RE: 11-06-2877P Response to FEMA Comments Dated 07/20/11

Response to FEMA Comments Dated 07/20/2011

LOMR Request 11-06-2877P

P:\COA05-060_LA_CUEVA_Channel\LOMRResponse 03-12\BermModPnP_0312.dwg waters Plotted: March 19, 2012 - 9:19am Layout: PLANPROFILE

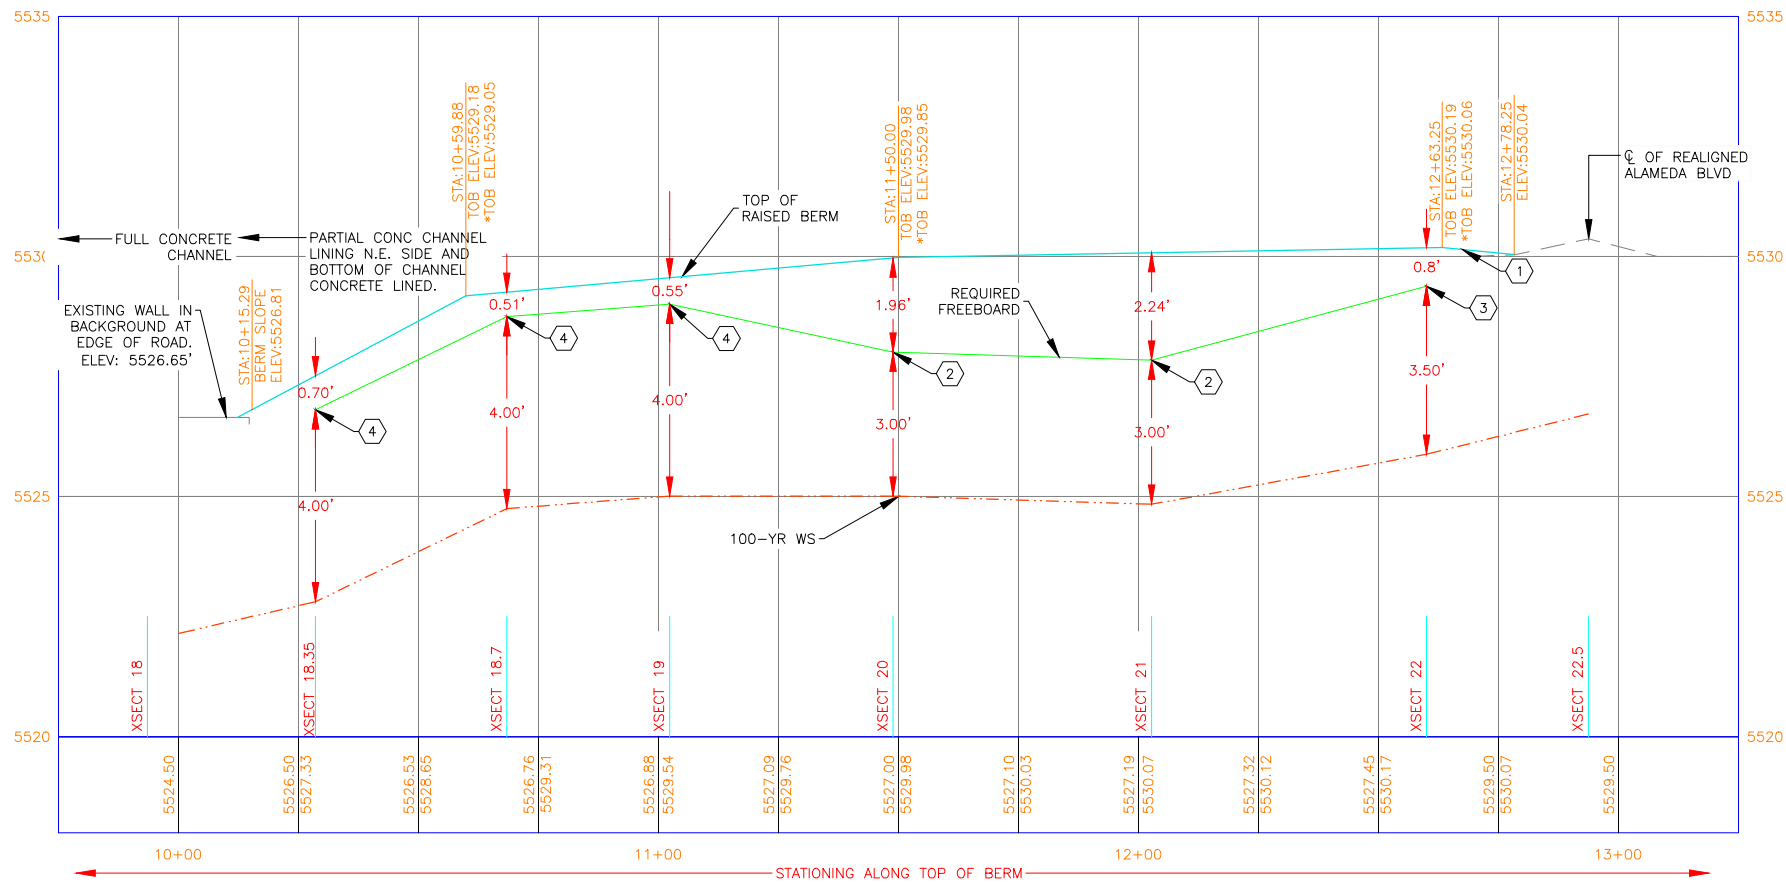
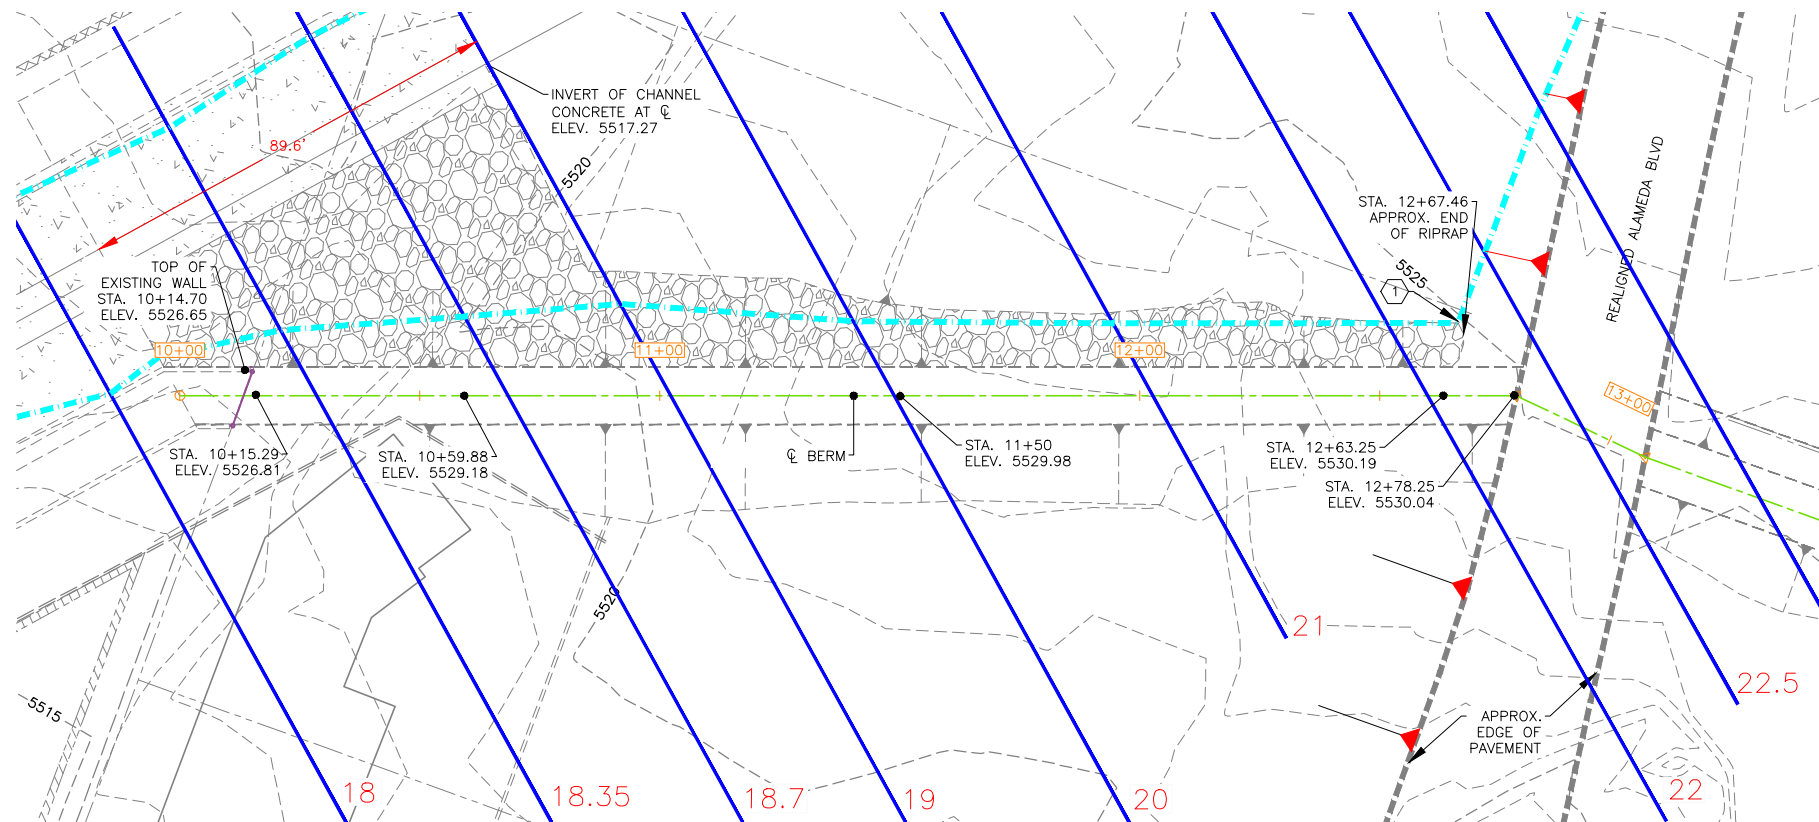
Comment 5: For the as-built profile with the base flood water surface and corresponding freeboard for the berm north of Alameda Blvd, please see Attachment E which is Sheet 2 of 3 from the Plans for Modification of La Cueva Channel Berm North of Alameda Blvd. The floodplain extent of the base flood does not reach the berm extending to the south from Alameda Blvd and connecting to the berm built prior to 1980, as shown on Attachment B, which is Appendix D, Figure 3 (Workmap) from our March 2011 submittal.

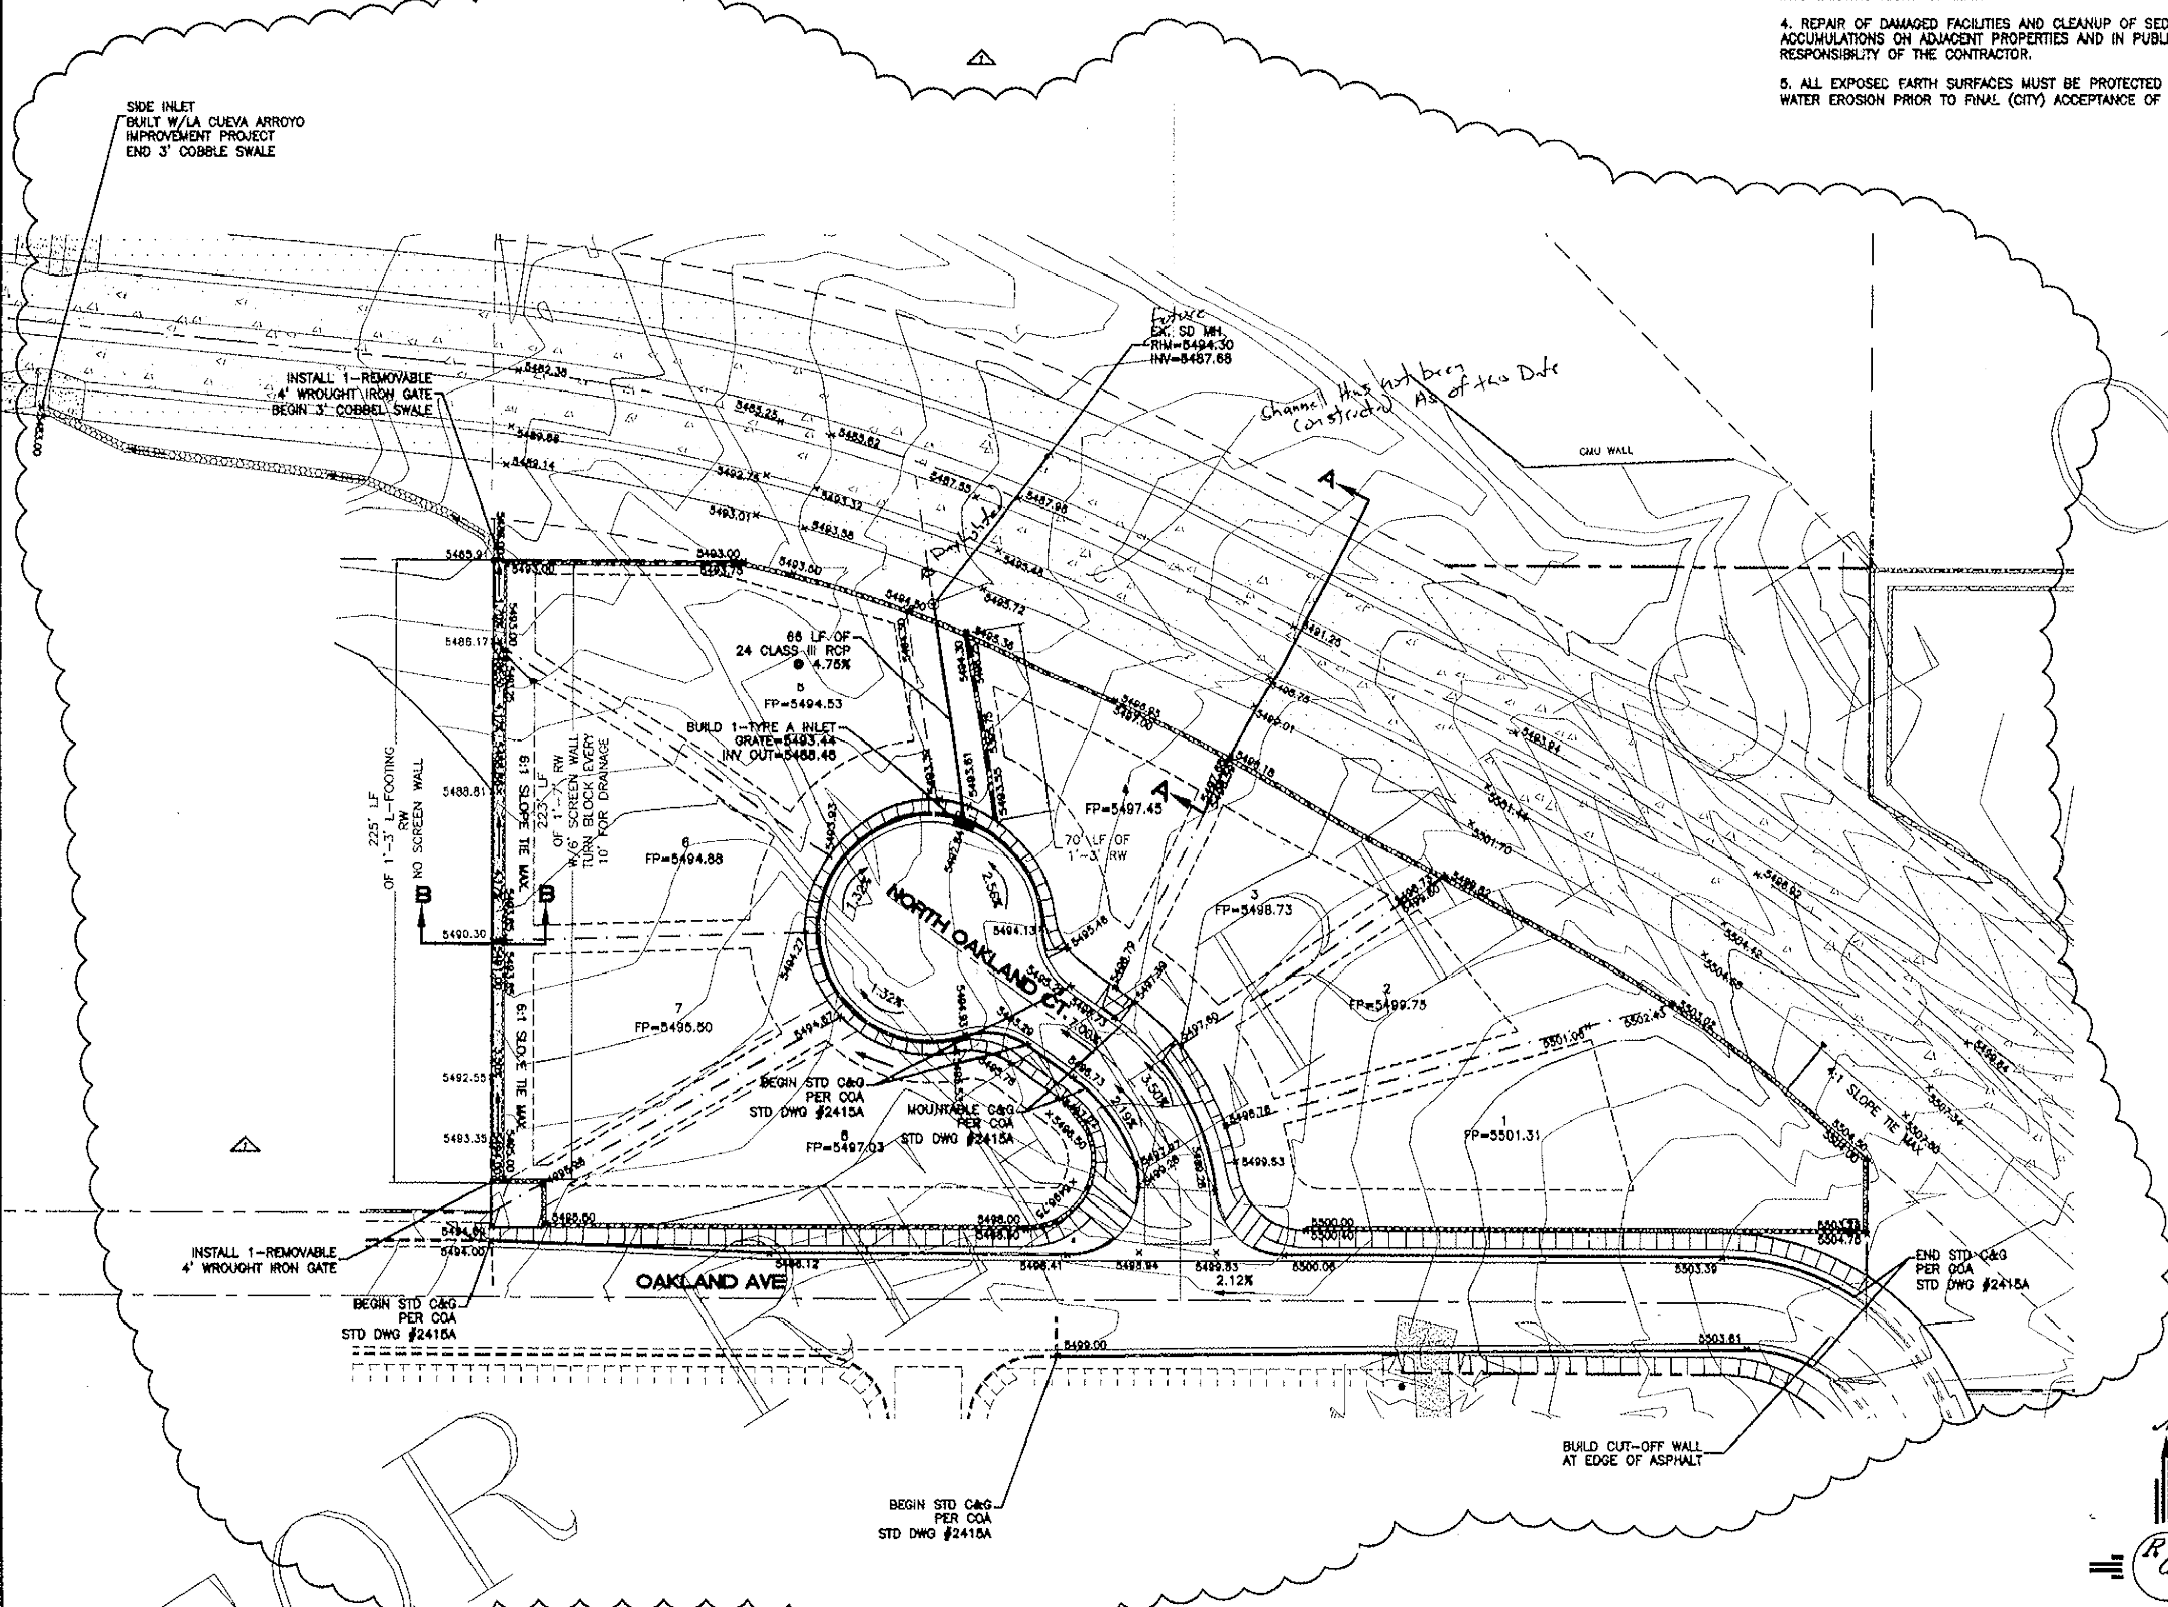
Comment 9: An interior drainage system is not needed and has not been designed. The land to the west of the berm has been developed. That development drains away from the berm and La Cueva channel as shown on Attachment H, which is the Grading Plan for Rich Court. The ultimate grading for this location, after the berm is removed, is shown on Attachment A5.

P:\COA05-060 LA CUEVA Channel\LOMR\Response 03-12\DWG\Workmap_0312.dwg\Workmap Plotted: March 21, 2012 - 10:38am Layout: Workmap 03-12

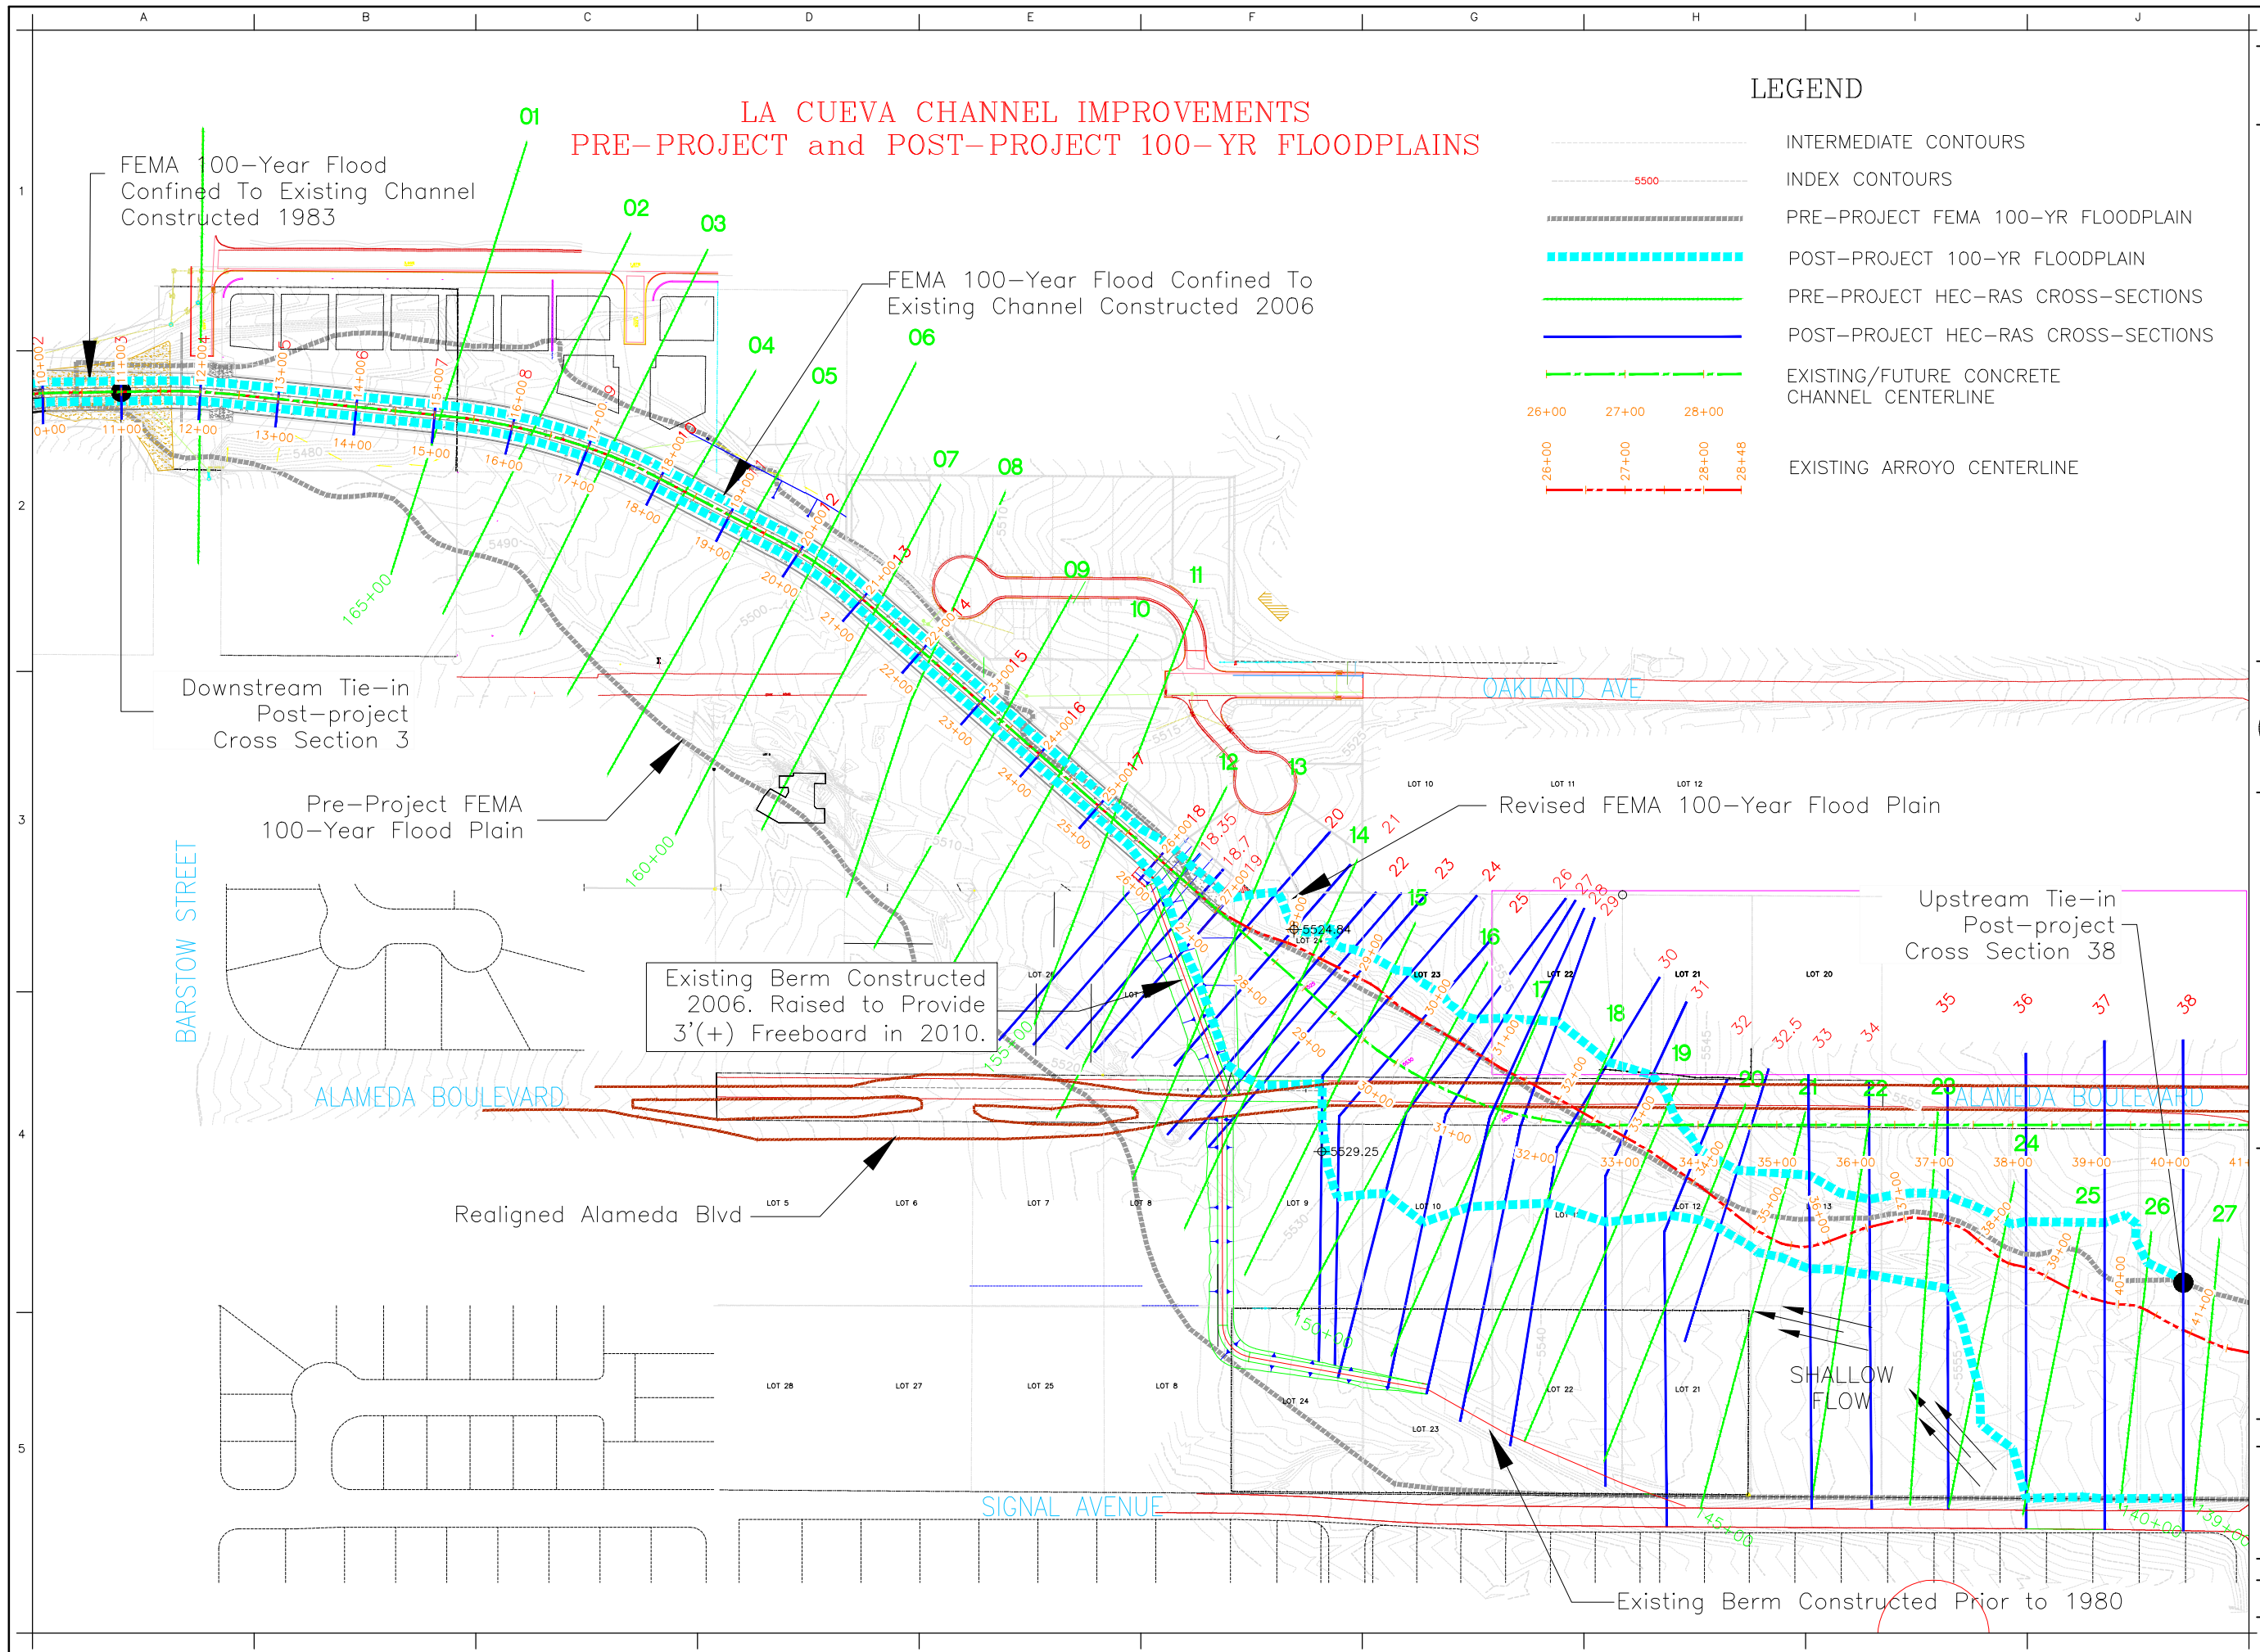
Comment 2: Please see Attachment B, which is Appendix D, Figure 3 (Workmap) from our March 2011 submittal in paper, .pdf, and CAD formats.

Comment 10: Weston provided no verification for berm opening closure devices because this berm has no openings. Please see Attachment B, which is Appendix D, Figure 3 (Workmap) from our March 2011 submittal.
